Please find attached a letter containing comments in respect of the revised application for 85 The Ridgeway, Northaw.

**Reference S6/2010/1555/FP- 85 The Ridgeway, Northaw
(amendments to application S6/2007/1588/FP)**

PROPOSED REAR ELEVATION

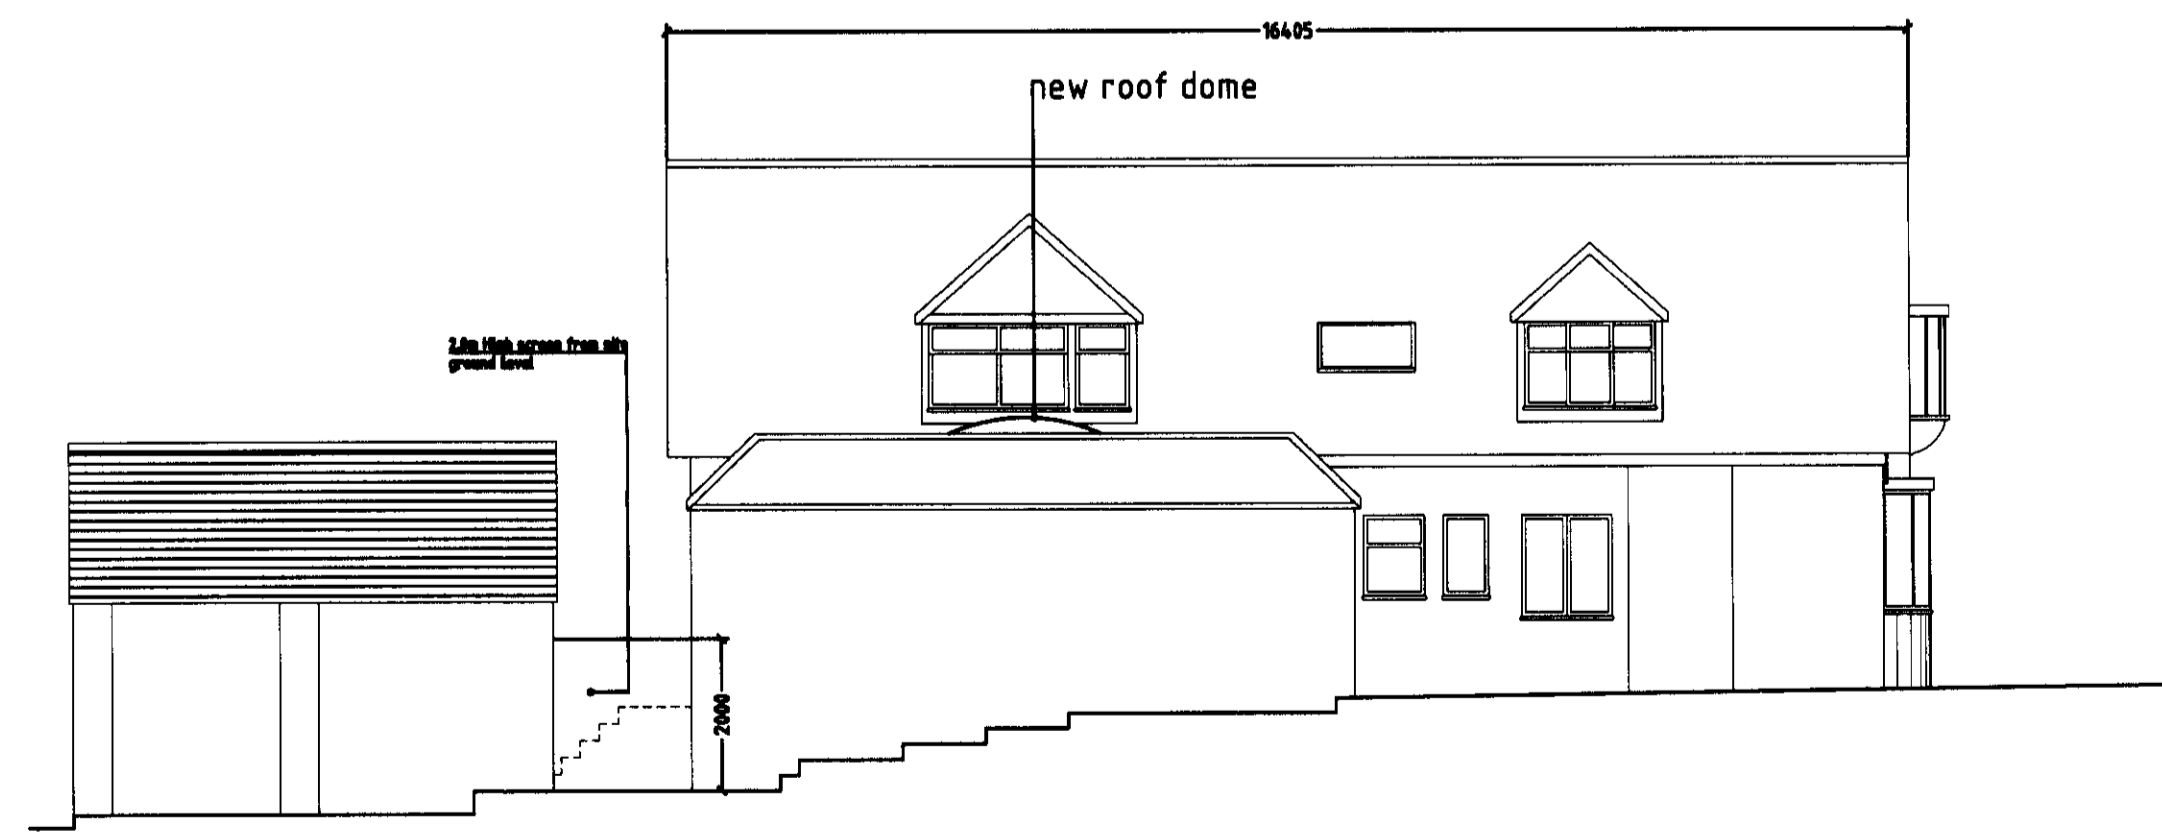
The garage extension is being built directly on our shared party wall line just 1 metre from the flank wall of our property. In the new proposed plans the rear wall of the garage is flush with the proposed kitchen extension and hence protrudes some 2.2m beyond the rear of our house causing overlooking concerns and a serious prominence issue. Despite the aforementioned being a single storey extension it stands over 4.5m from ground level, as can be seen in *appendix photographs 'A' & 'B'*. I suspect the height consideration was overlooked when the original plans were first approved.

It is pleasing to note that the rear garage door has now been reduced to a window only, and that the rear veranda will now stop at the kitchen.

PROPOSED ROOF PLAN 1:100

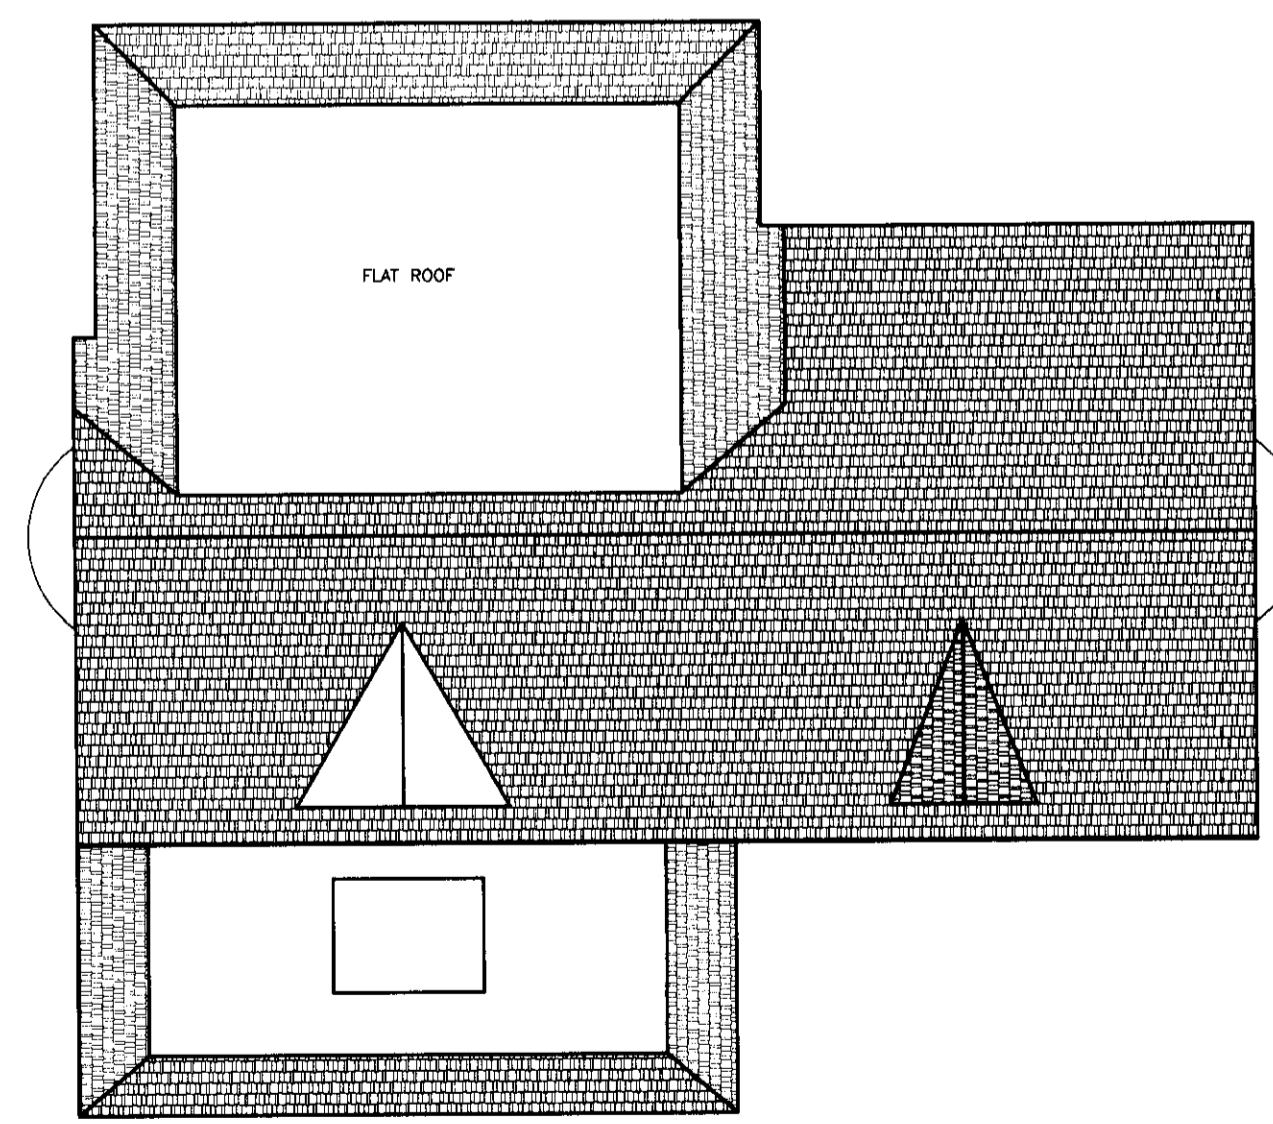
Two of our first floor bedrooms have windows with west facing elevations which look onto the pitched roof of the garage extension. It would appear that potential loss of daylight or the proximity to our windows was not given appropriate consideration when the original plans were passed. *Appendix Photograph 'C' & 'D'* shows the close proximity of the new garage roof.
